OXFORDSHIRE COUNTY COUNCIL'S RESPONSE TO CONSULTATION ON THE FOLLOWING DEVELOPMENT PROPOSAL

Application no: 21/02339/REM

Proposal: Reserved Matters application for 14/02121/OUT, Phase 1 Development of 500 dwellings, landscaping, new vehicular, cycle and pedestrian access routes and other operations

Location: Proposed Himley Village North West Bicester, Middleton Stoney Road, Bicester

TITLE
**S278 OFFSITE HIGHWAY WORKS
SPINE ROAD ACCESS
GENERAL ARRANGEMENT
SHEET 1**

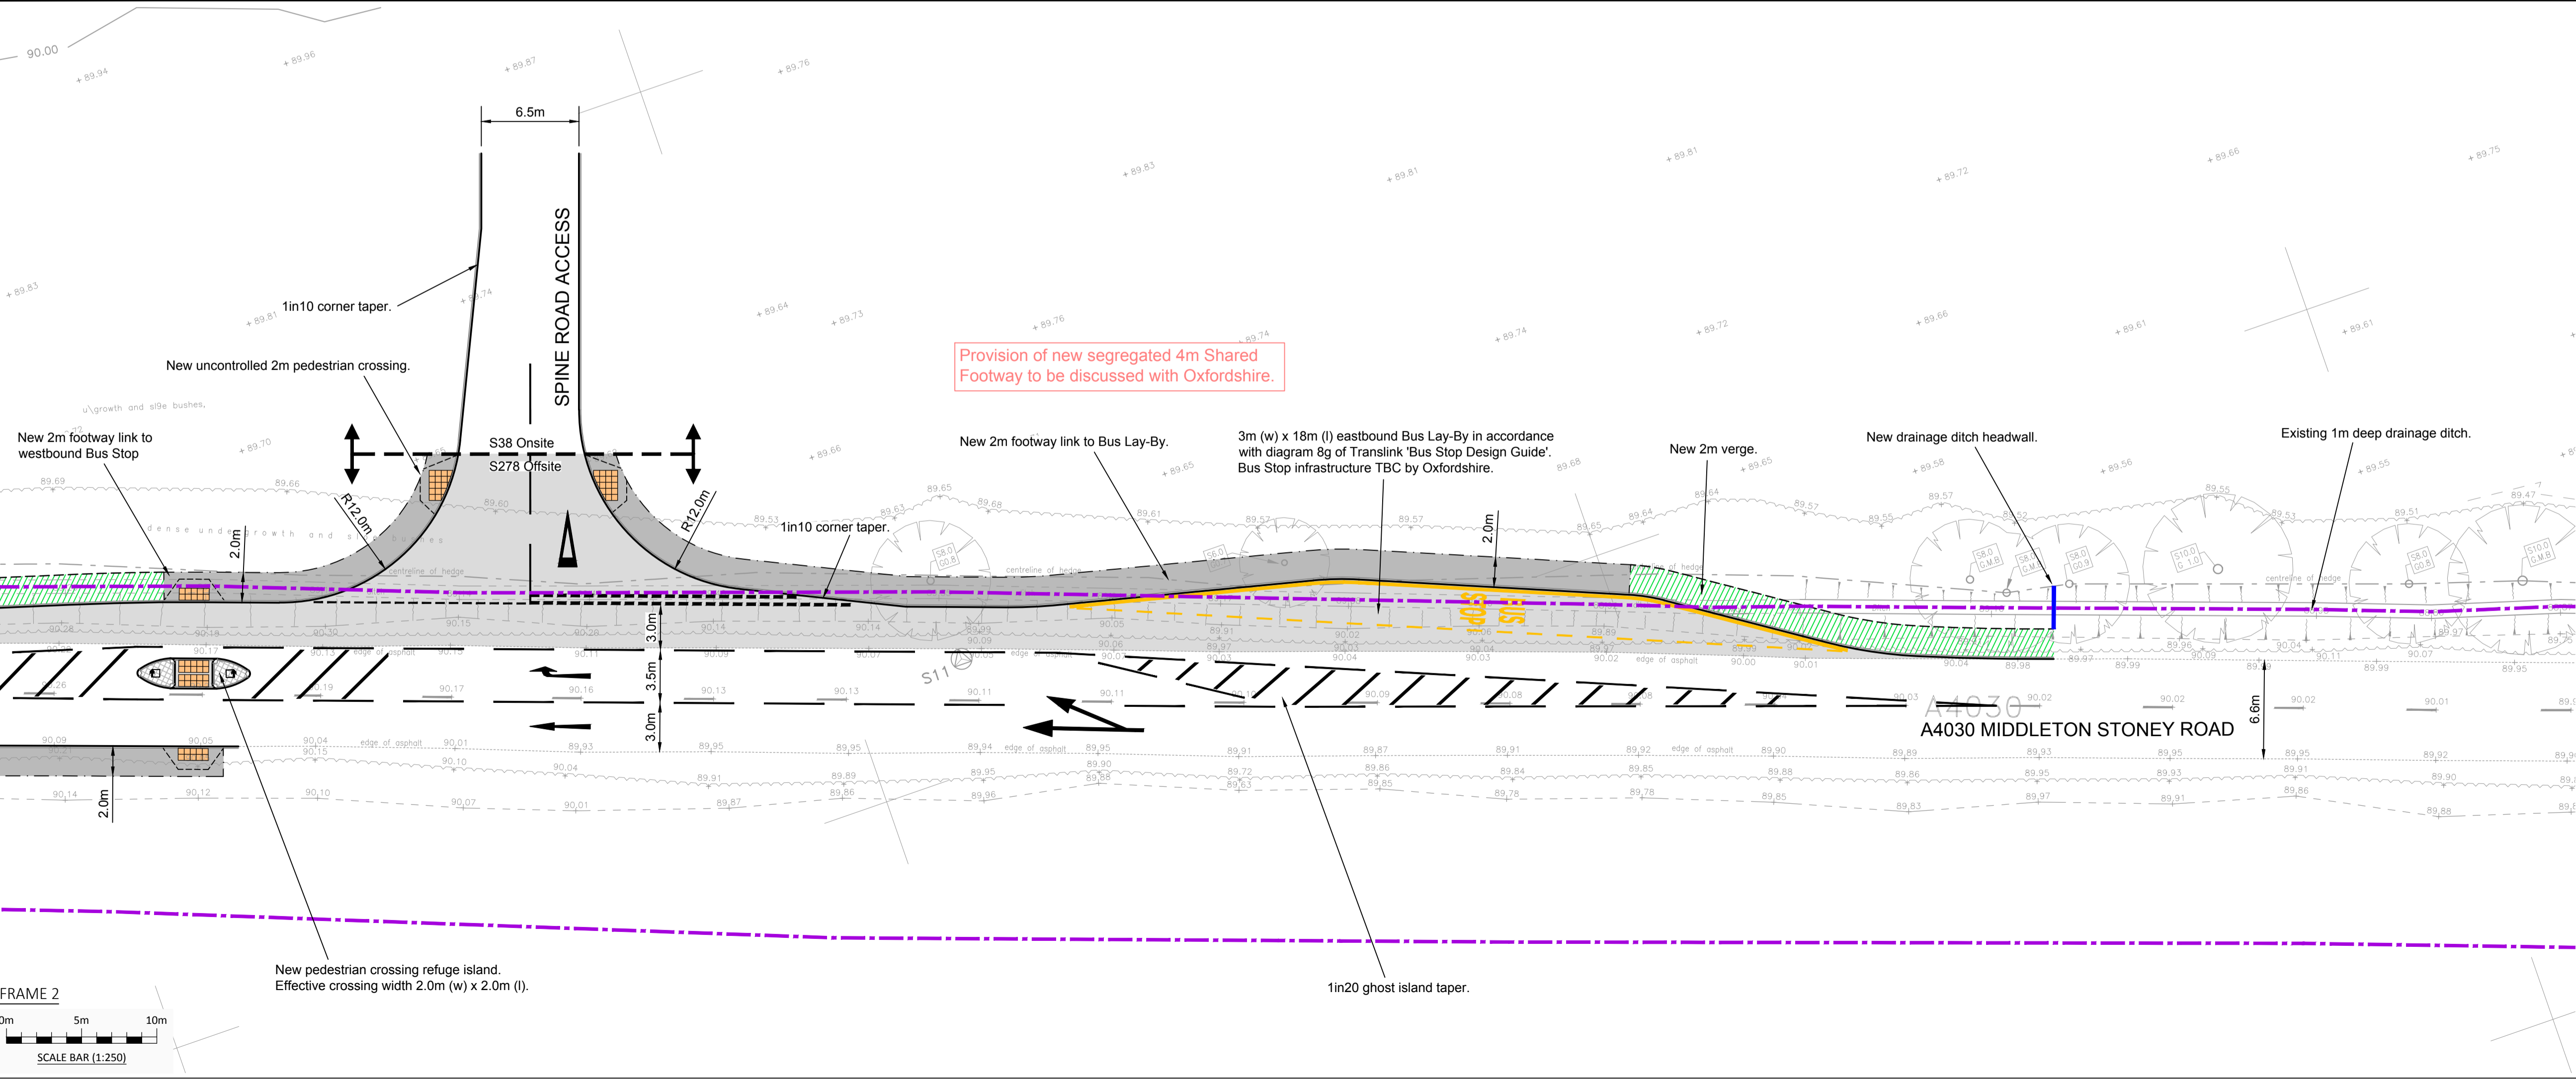
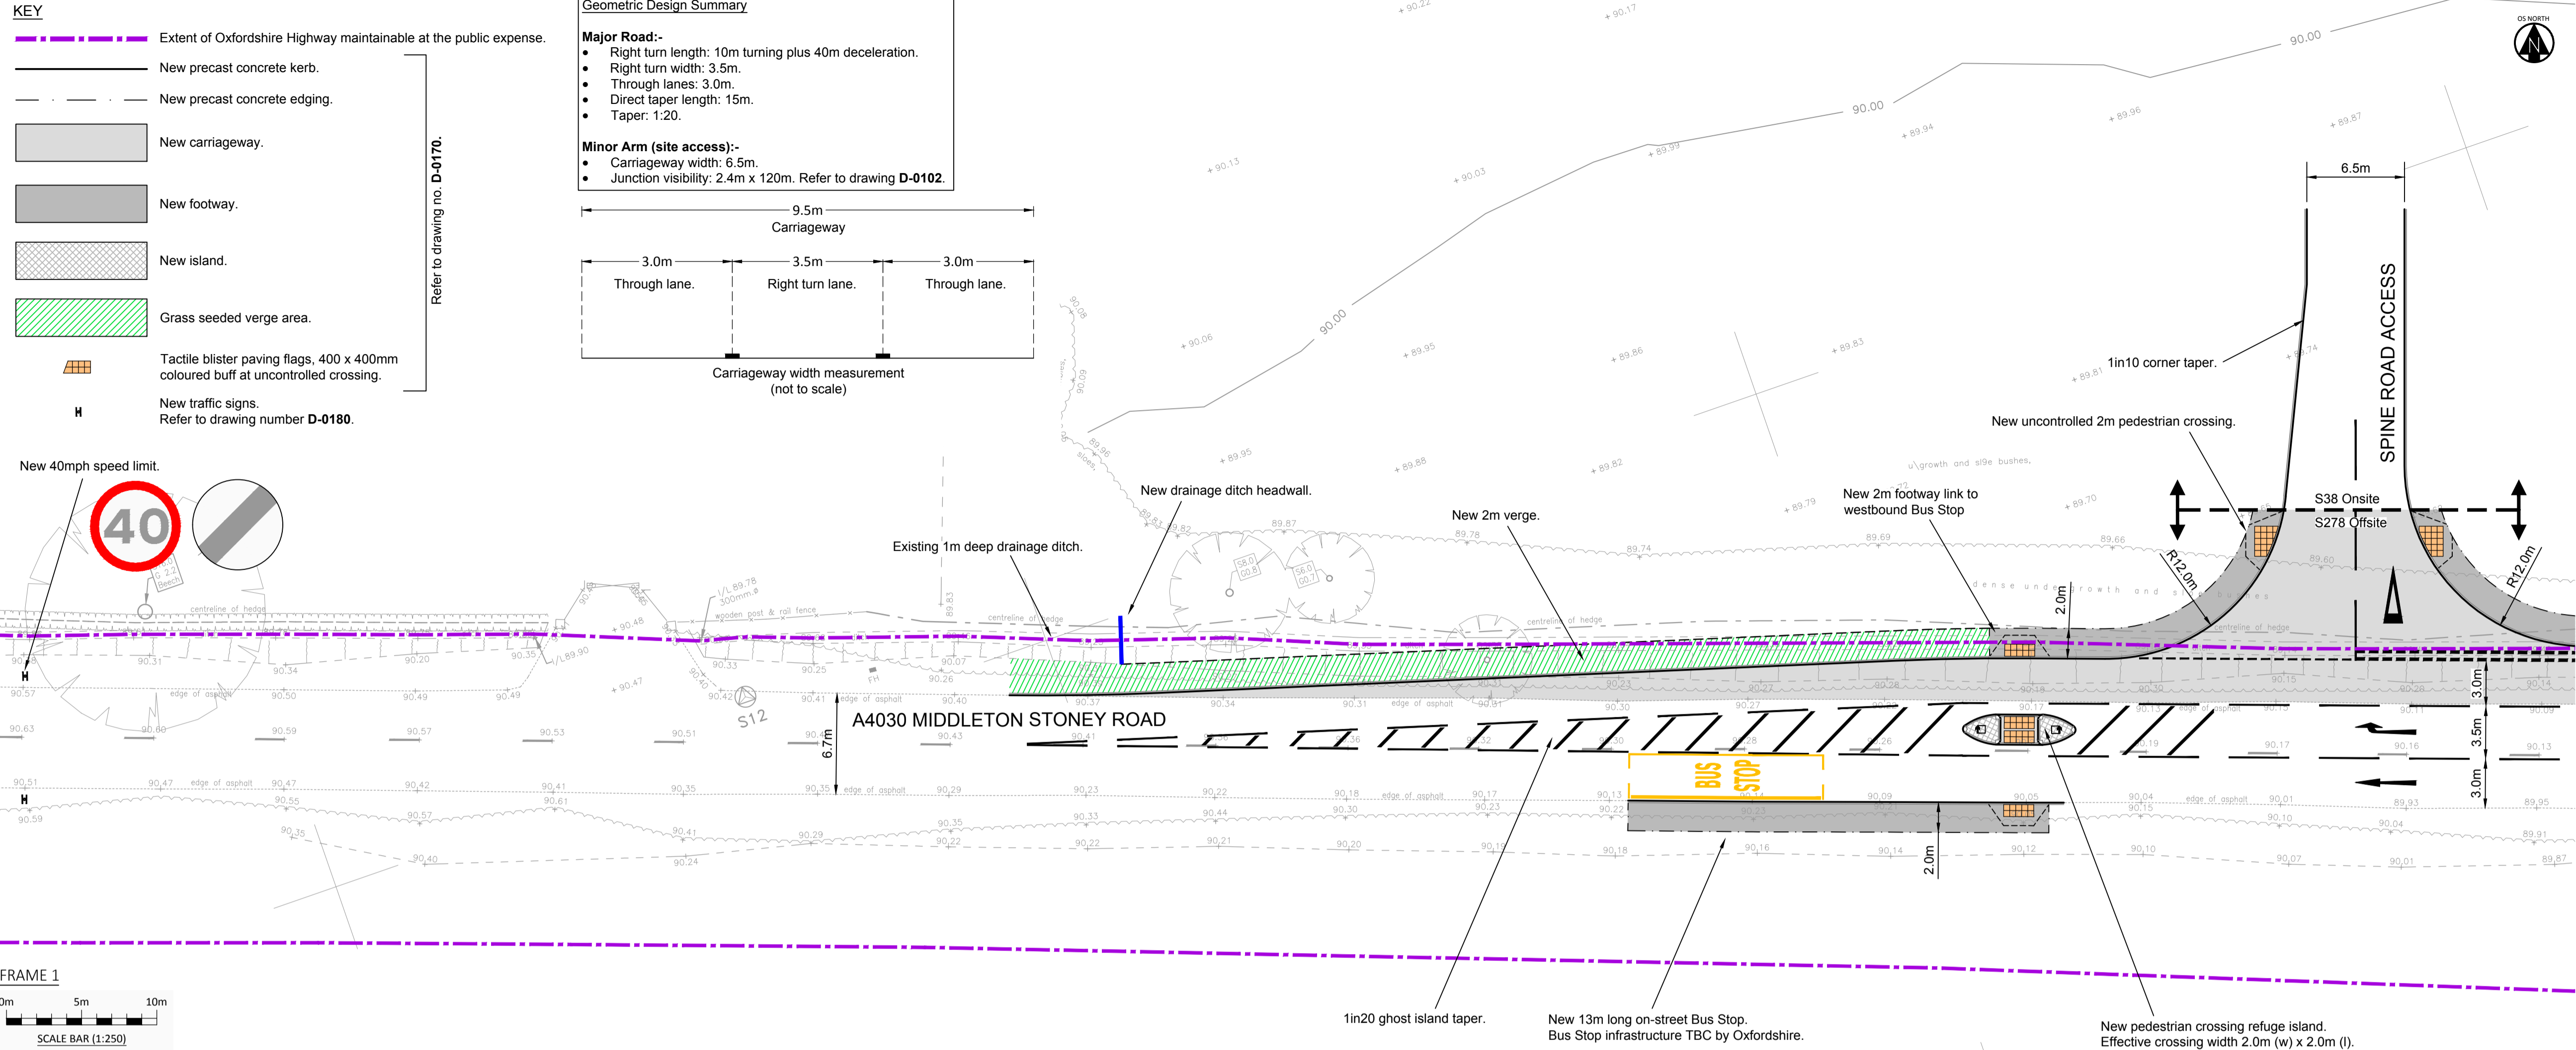
Access points to/from Middleton Stoney Road, and on-site junctions to be used by bus, must be suitable for full size single deck buses (up to 12.2m in length) to make suitable turns.

The only bus stop provision explicitly made at any point in the submissions is a single new pair on Middleton Stoney Road. On their own, this is neither adequate, convenient nor attractive for the majority of development residents, given that a dedicated service is unlikely to be provided for a significant period of time; however, it is important to provide some kind of choice for the very first occupiers, as it clearly would be infeasible to bring any service into the site for some time, until the interim on-site bus route is constructed and open for public use.

It is considered that a third stop should be provided on the access arm into the site, down-stream of the junction. This will serve the mixed-use area, complementing the currently proposed provision on Middleton Stoney Road. Such an arrangement is good practice. Bus stops (five in total) must be delivered as indicated by the red dots on the above plan, which will enable access to the development both before and after the route through the development is available. A pair of stops must also be provided on the link road between the two access points, in the centre of the proposed Phase 1 development. It is imperative that bus access through the development must be available at the earliest opportunity and certainly no later than occupation of 220 dwellings.

- Hyder (September 2010). NW Bicester Eco- Town - Exemplar Site, Factual Report. Document reference: 2504-UA001881-UP33R-01
- Hyder (November 2010) NW Bicester Eco Development, Geotechnical Interpretative Report - Exemplar Site. Document reference: 2505-UA001881-UP33R-01

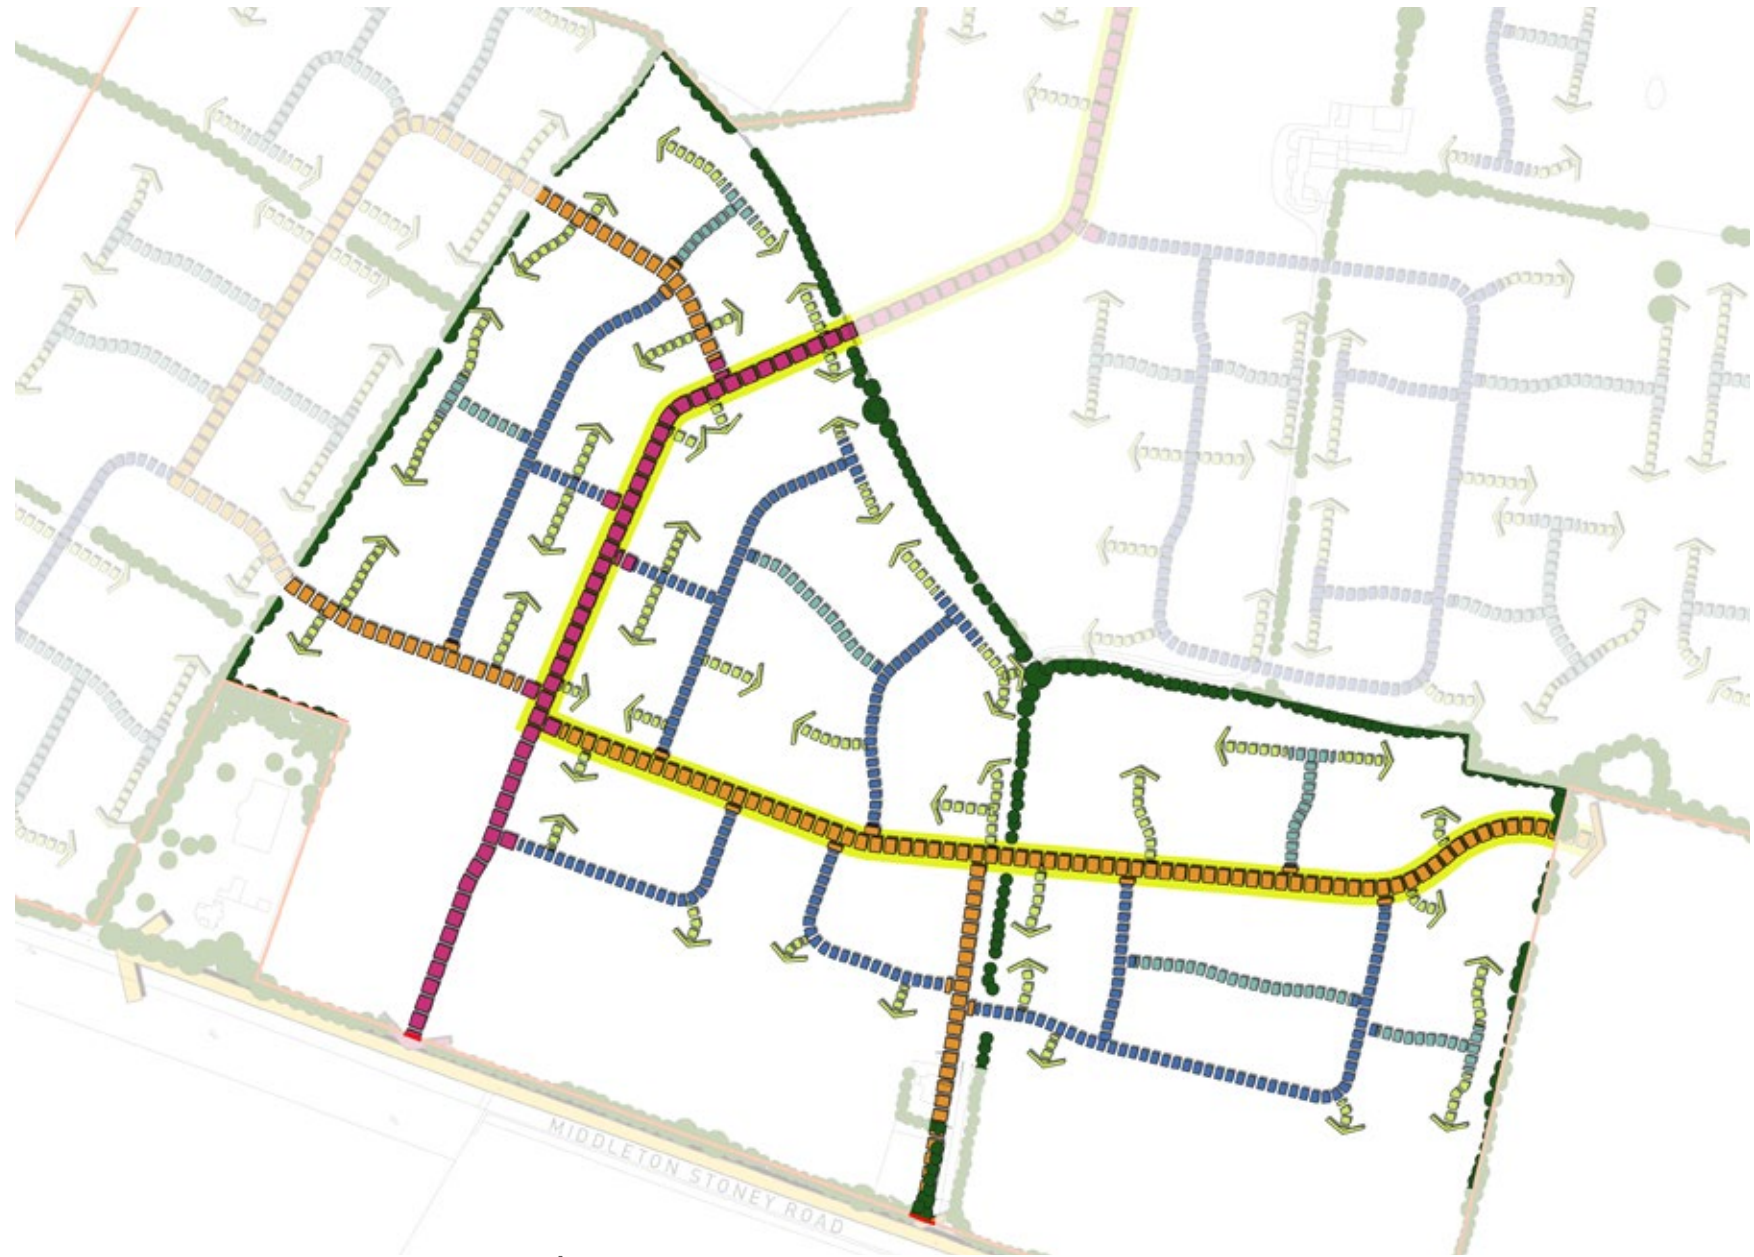
The cycle infrastructure within the site is not in line with national guidance LTN 1/20 which has been released since the application was first agreed. LTN 1/20 stipulates a

number of design standards for pedestrian/cycle infrastructure which must be considered when constructing new infrastructure schemes. It does not appear that the provision shown is in line with what is required and as such an objection is raised until the appropriate infrastructure is provided.

- 3) Onsite routes. I also feel the routes denoted for pedestrians marked with yellow dots should be designated and provided as shared use paths for walkers and cyclists as this will encourage active travel and give an onsite connection to offsite routes. These should be minimum 3-4m surfaced width, with surface of compacted stone or blacktop – with details to be agreed in advance. This complements the roadside cycle access indicated for future development parcels.
